From: Laura Gibbons
Sent: 26 March 2018 11:39
To: Planning.Responses
Subject: RE: Planning Consultation on: A/25/18/DOC

APPLICATION NO: A/25/18/DOC

Site Address: Herons Farm Dappers Lane Angmering

Description of Works: Approval of details reserved by condition imposed on planning permission A/184/15/PL relating to condition no.5 - drainage

© This drawing is the copyright of Robert Clark Associates Limited It may not be copied or reproduced without their written authority	
Scale 1:250	At original A3
Drawing Number 1774/D1.1	Revision -

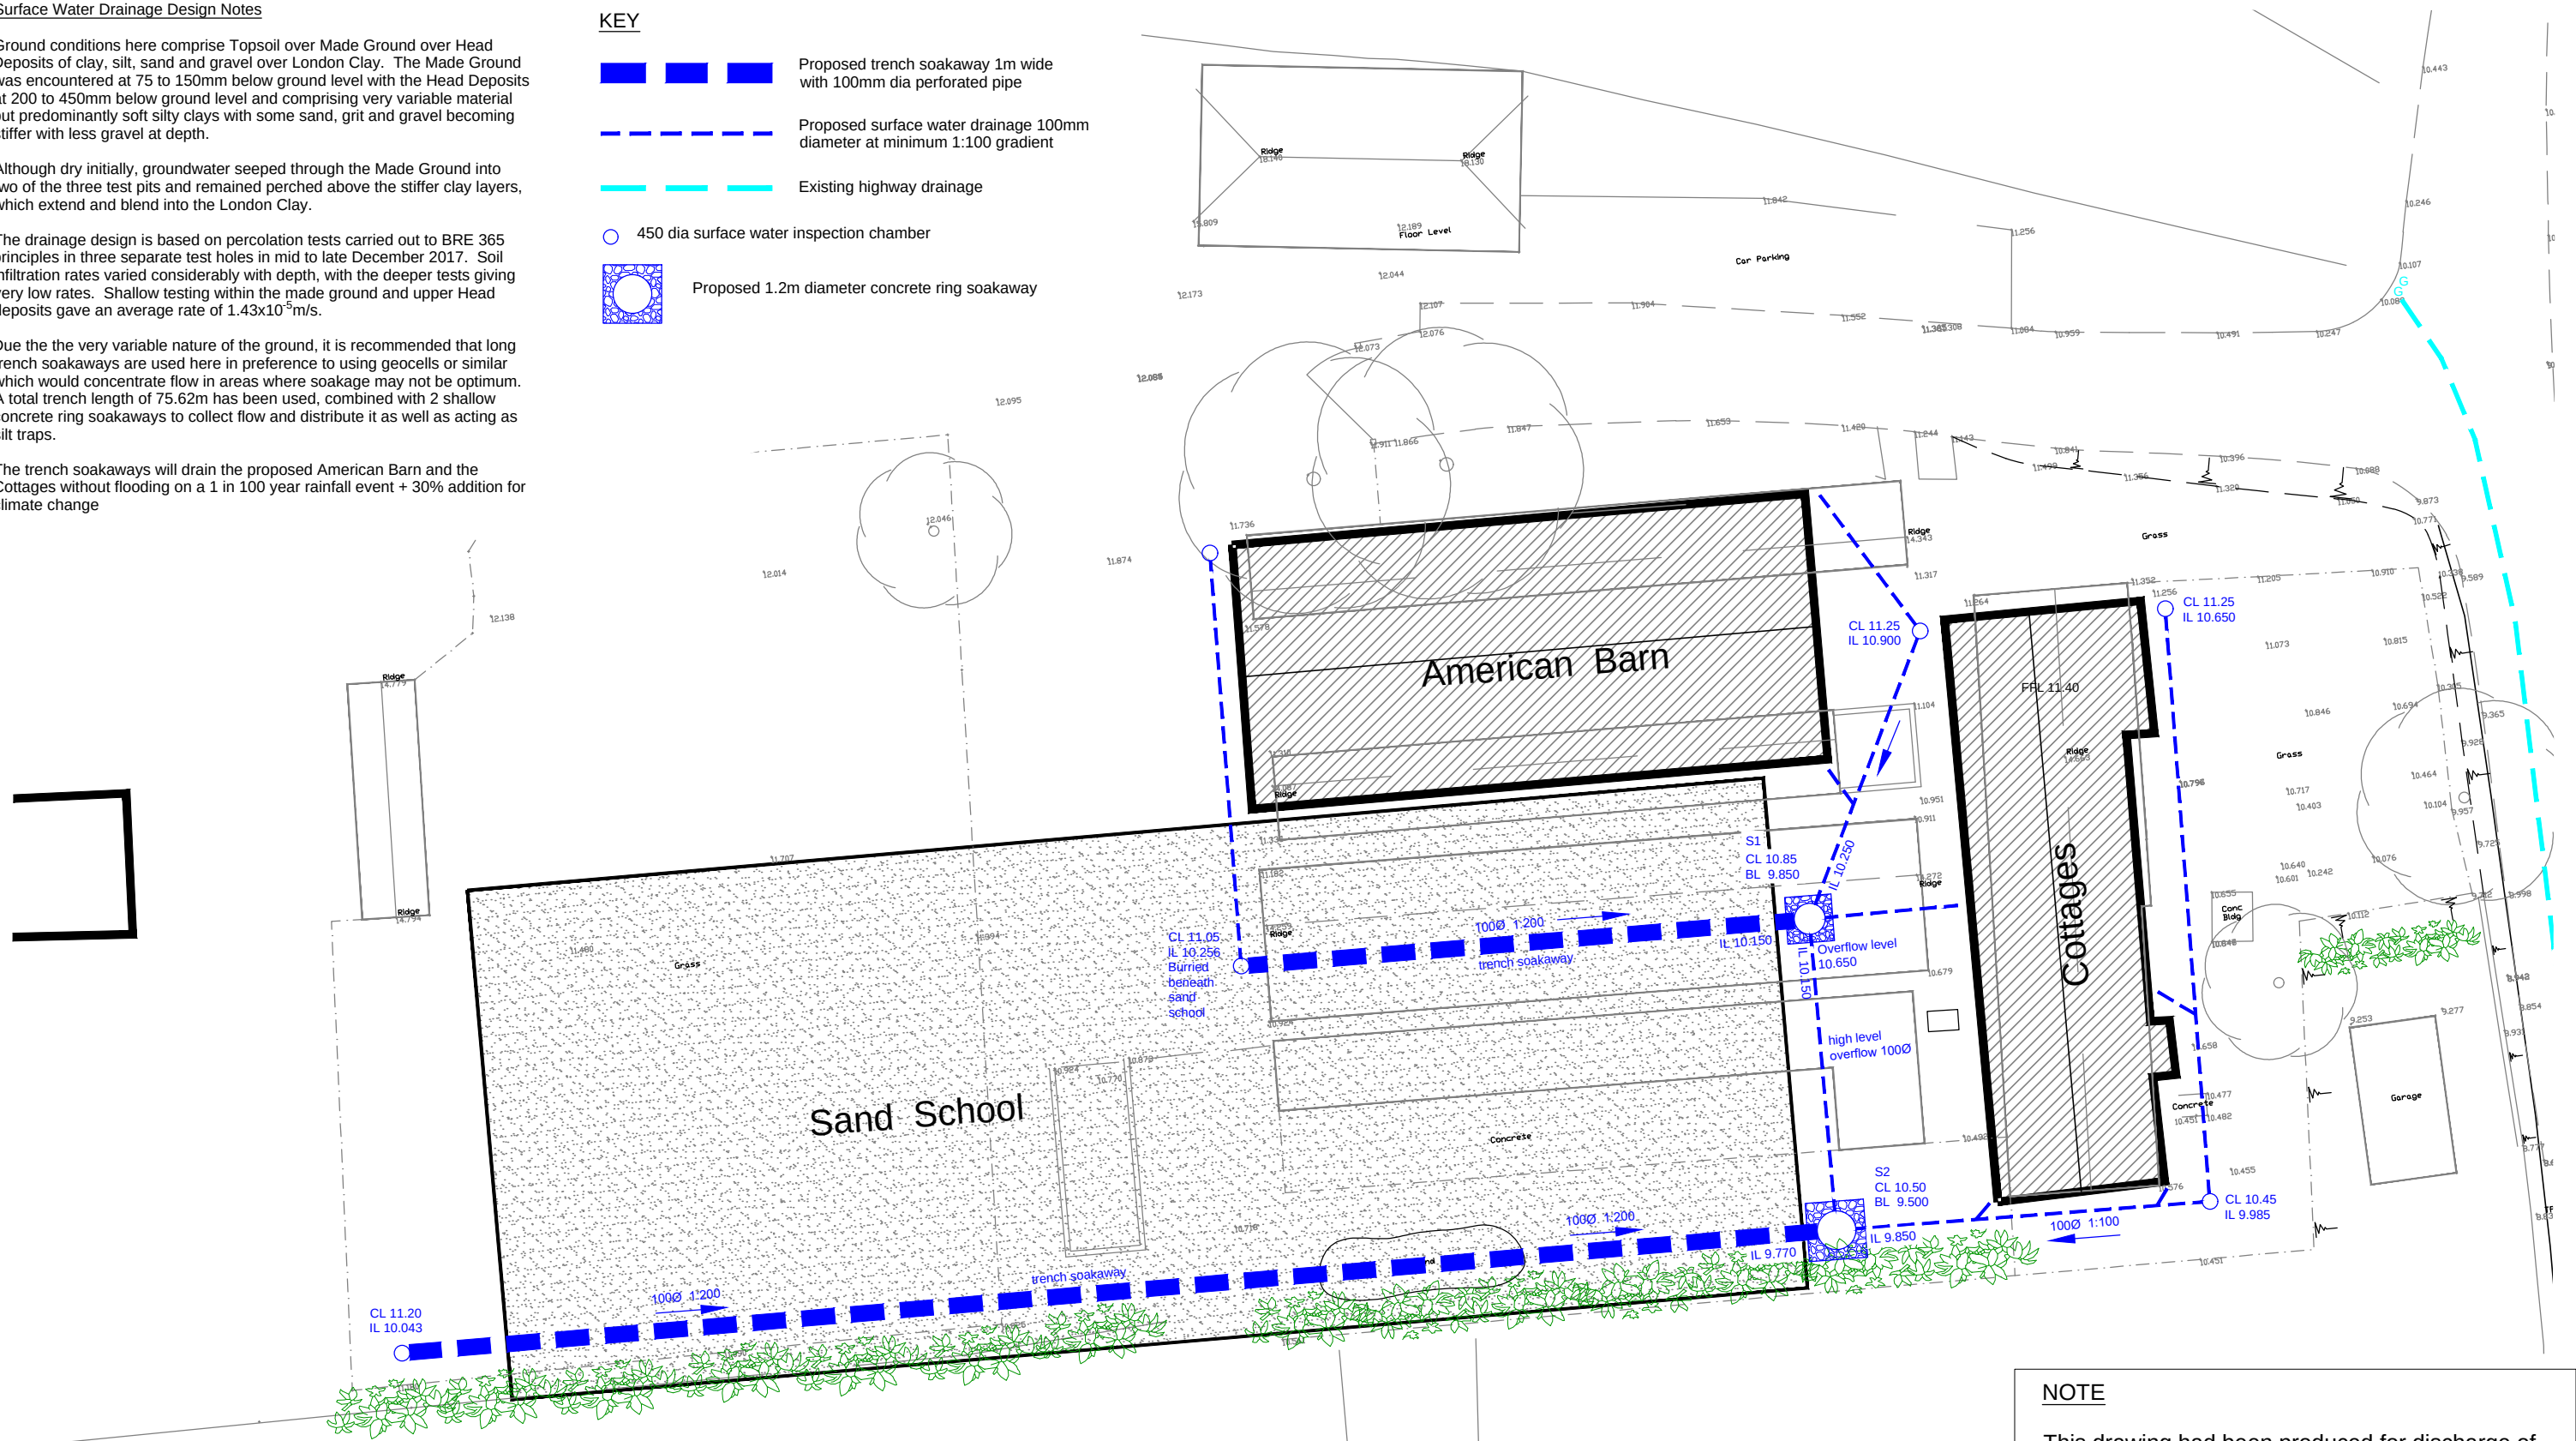
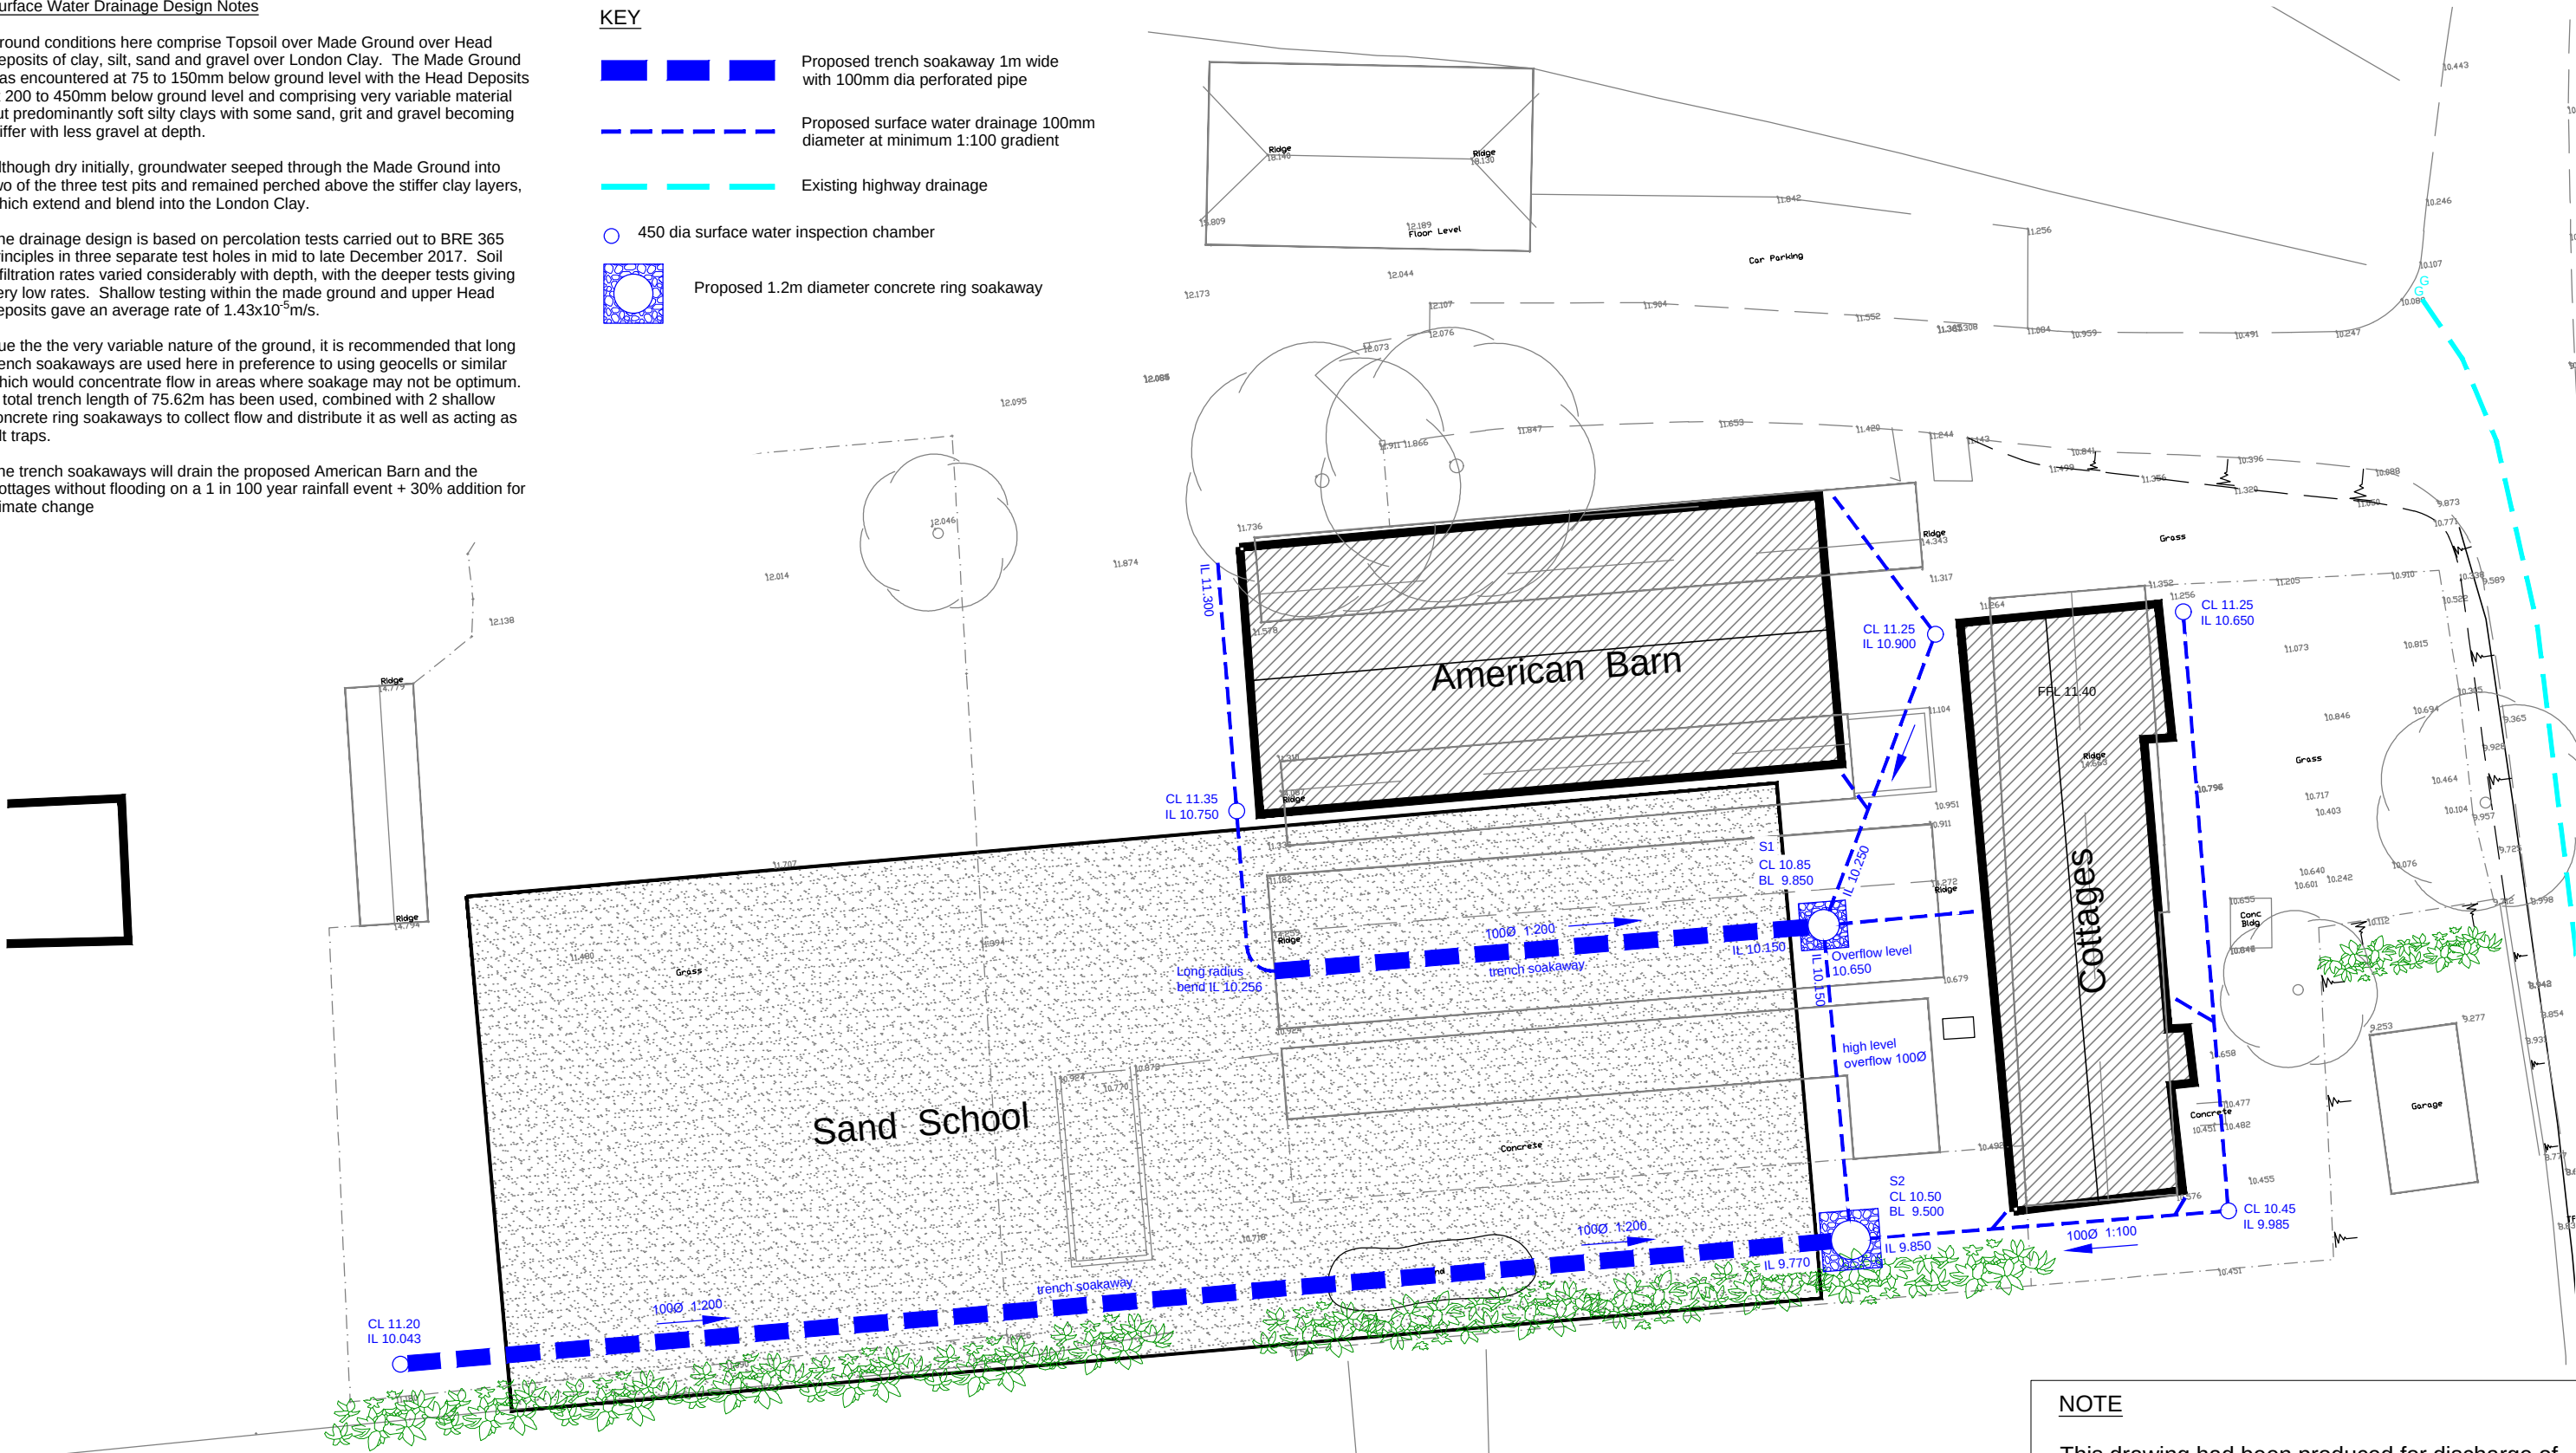
- Please supply winter ground water levels.
- Please move the manhole which is currently underneath of the Sand School to be outside of the Sand School.
- It is noted that the porosity used in drainage calculations is 0.4, please adjust this to 0.3 or provide robust evidence that 0.4 will be achieved.
- Specify all levels on manholes.
- Provide construction details of the sand school, will it drain into the system?
